CITY OF ALBUQUERQUE

Re: WAREHOUSE ON ASPEN
300 Aspen Avenue NW
Approval of Permanent Certificate of Occupancy (C.O.)
Engineer's Stamp dated 04/04/2003 (J-14/D145)
Certification dated 03/20/2006

REFERENCE: Grading and Drainage Plan for Tract A-2, located at 300 Aspen Avenue NW, (J14-D145)

**DRAINAGE AND GRADING PLAN
FOR ASPEN/3RD STREET BUILDINGS
300 ASPEN AVENUE N.W.**

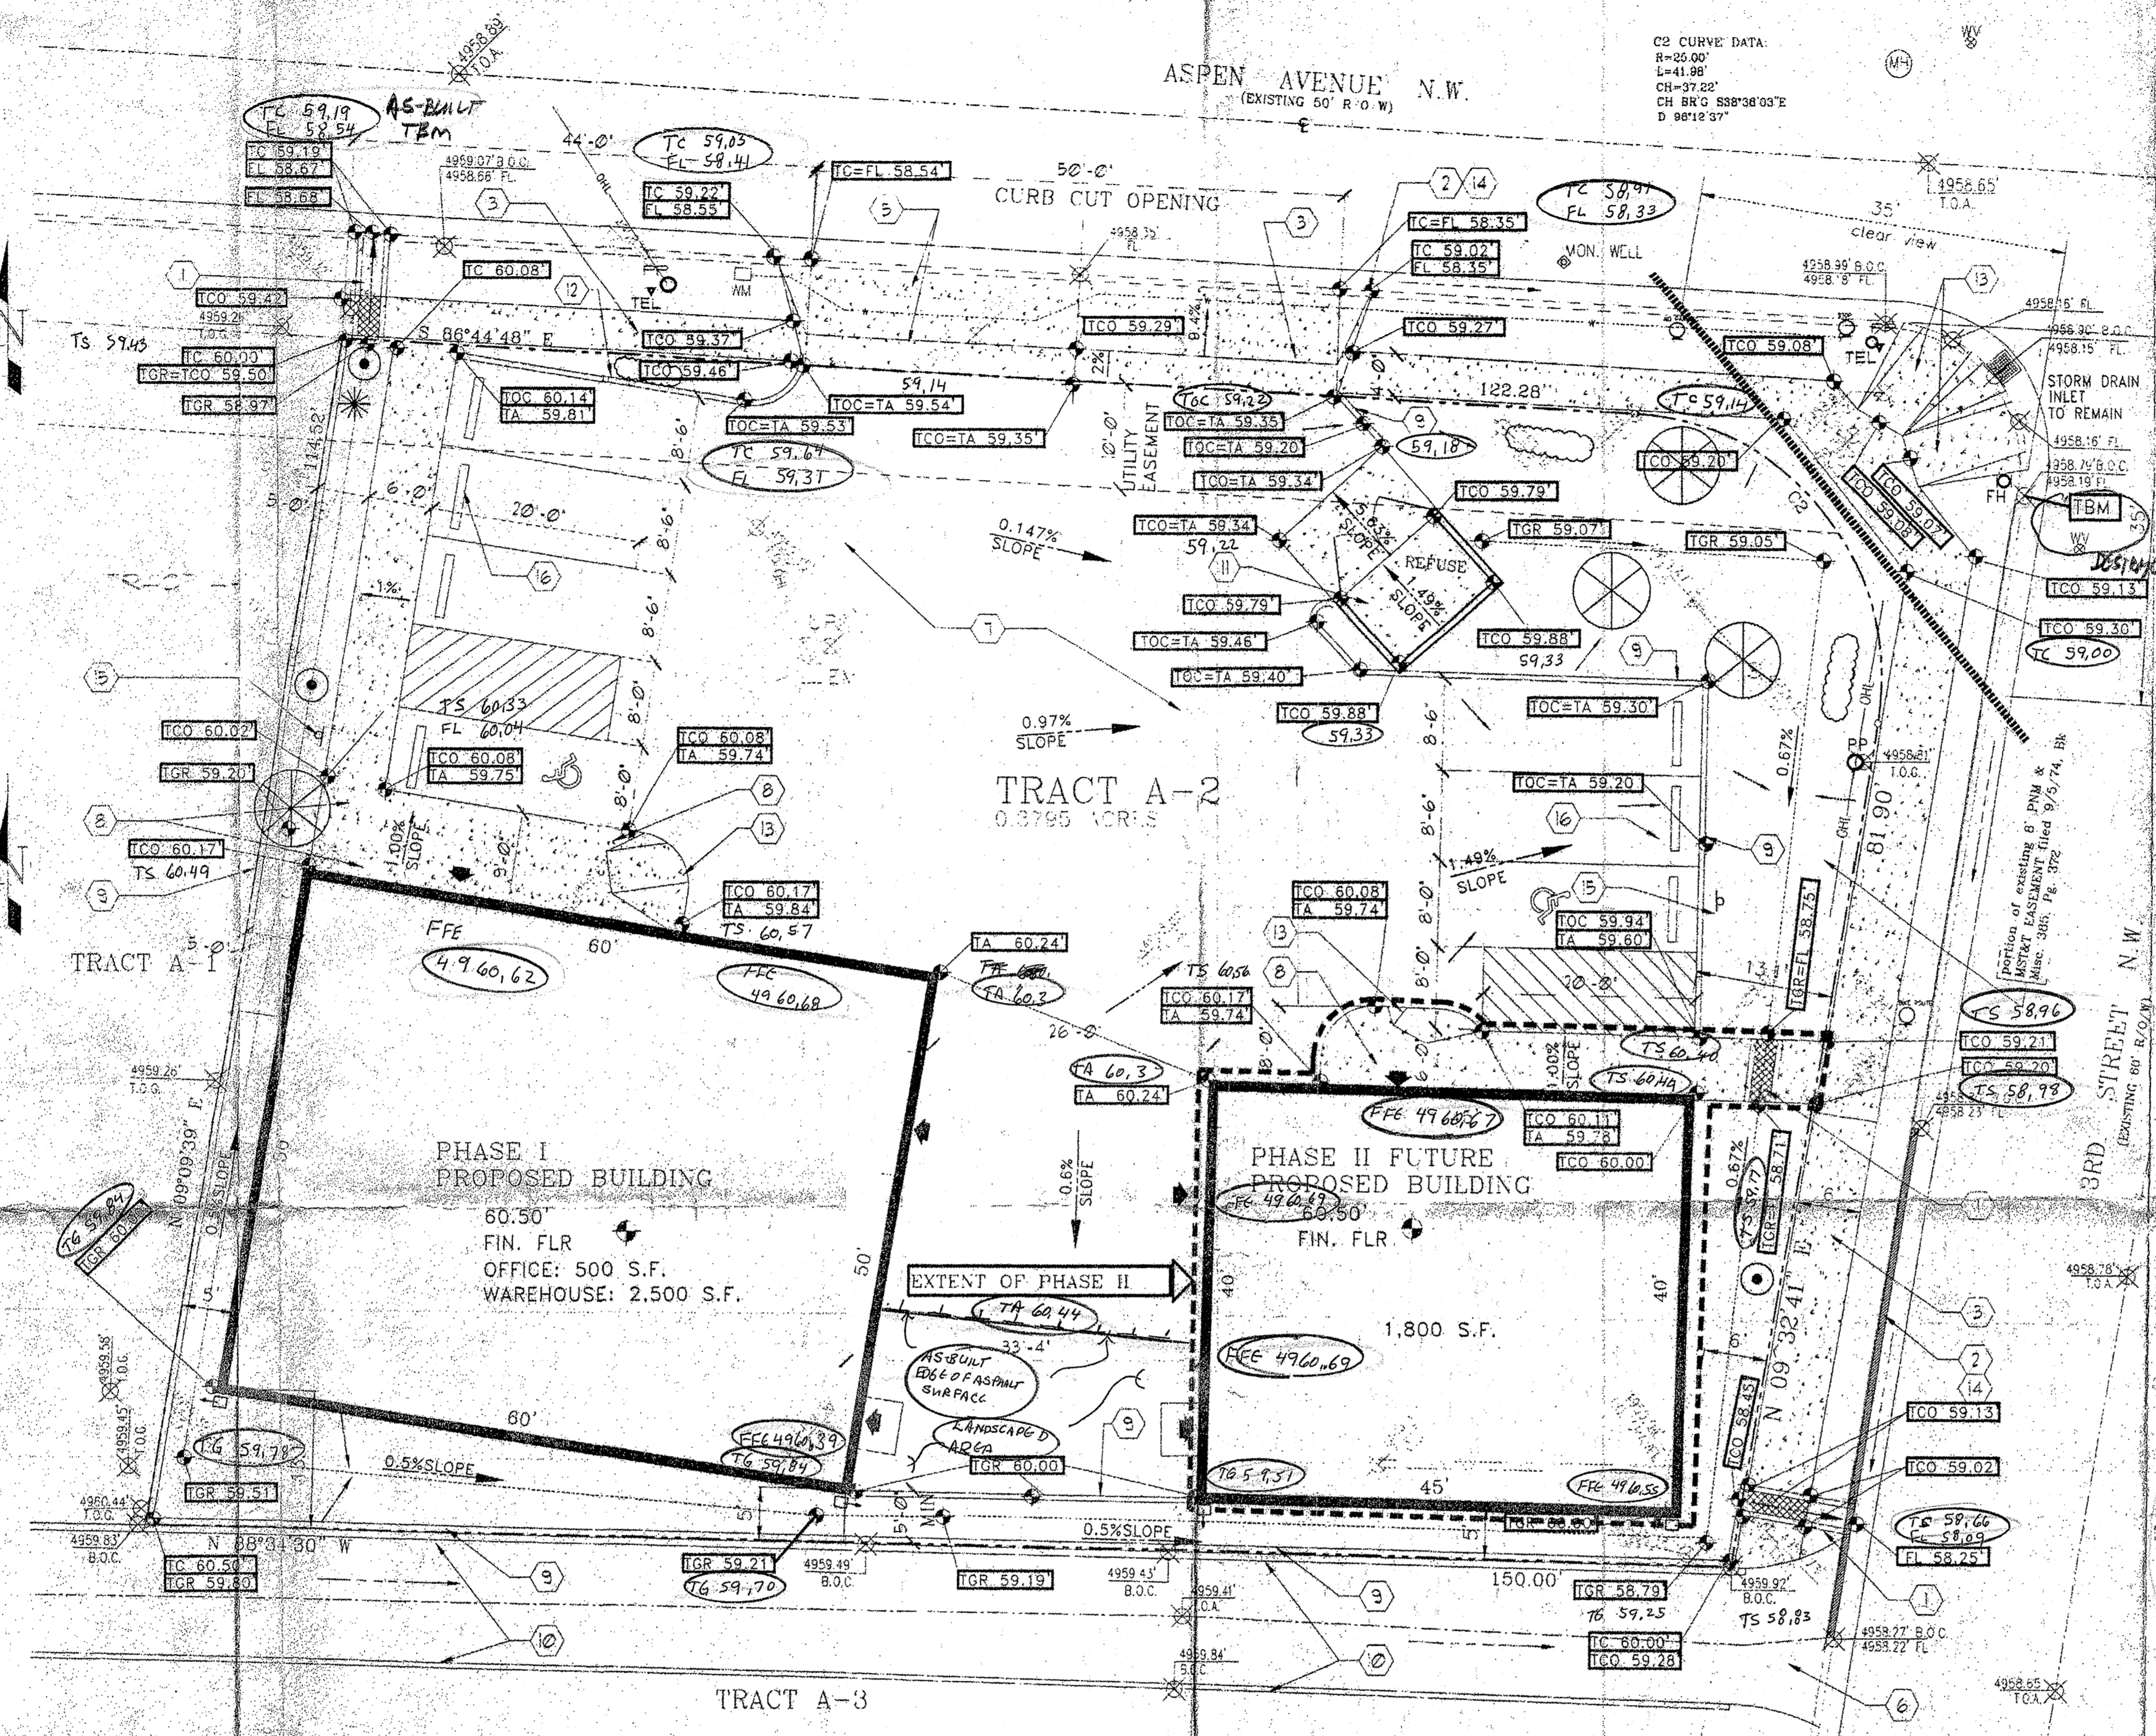
- The following improvements are required to be substantially complete:
 1. Install roof gutters on south side of both building to direct roof runoff to asphalt area on north side of buildings.
 2. Install treated timber curbing along the south property line of site and between refuse pad and sidewalk.
 3. Re-grade asphalt area to direct runoff from buildings and parking area to drive-pad at Aspen.
 4. Sidewalk culverts are not required if the majority of the site runoff can be directed to the drive-pad at Aspen.
- Show proposed improvements and as-built elevations on the approved grading and drainage plan.
- Provide stamped and signed drainage certification language on approved grading and drainage plan.

- The following improvements are required to be substantially complete:
 1. Install roof gutters on south side of both building to direct roof runoff to asphalt area on north side of buildings.
 2. Install treated timber curbing along the south property line of site and between refuse pad and sidewalk.
 3. Re-grade asphalt area to direct runoff from buildings and parking area to drive-pad at Aspen.
 4. Sidewalk culverts are not required if the majority of the site runoff can be directed to the drive-pad at Aspen.
- Show proposed improvements and as-built elevations on the approved grading and drainage plan.
- Provide stamped and signed drainage certification language on approved grading and drainage plan.

REVISIONS TO THE ORIGINAL PLAN, REVIEWED AND APPROVED BY THE HYDROLOGY SECTION ON OCTOBER 6, 2005, HAVE BEEN CONSTRUCTED, AS DESCRIBED BELOW:

- A. THE RUNOFF FROM IMPERVIOUS SURFACES THAT FLOWS TO THE SOUTH PART OF THE PROPERTY FROM THE SOUTH HALF OF THE PITCHED ROOF ON THE TWO BUILDINGS IS NOW DIRECTED TO A GUTTER AND DOWN SPOUT INSTALLED ON THE BUILDINGS, WITH THE DOWN SPOUT DIRECTING THE ROOF RUNOFF TO THE ASPHALT DRIVEWAY BETWEEN THE TWO BUILDINGS.
- B. A TREATED TIMBER CURB IS SUBSTITUTED FOR THE CONCRETE HEADER WALL THAT WAS APPROVED ALONG THE SOUTH AND WEST PROPERTY LINES.
- C. THE ASPHALT SURFACED DRIVEWAY HAS BEEN RE-SURFACED TO DIRECT RUNOFF TSO THE RIVEWAY AND INTO THE GUTTER ALONG ASPEN AVENUE NW.
- D. THE SIDEWALK CULVERTS AT THE SOUTHWEST CORNER, ON ASPPEN AVENUE NW, AND AT THE NORTHEAST CORNER, ON 3RD STREET HAVE BEEN DELETED AS A REQUIREMENT BECAUSE ALL RUNOFF FROM IMPERVIOUS SURFACES IS DIRECTED TO THE DRIVEWAY ON ASPEN AVENUE NW.
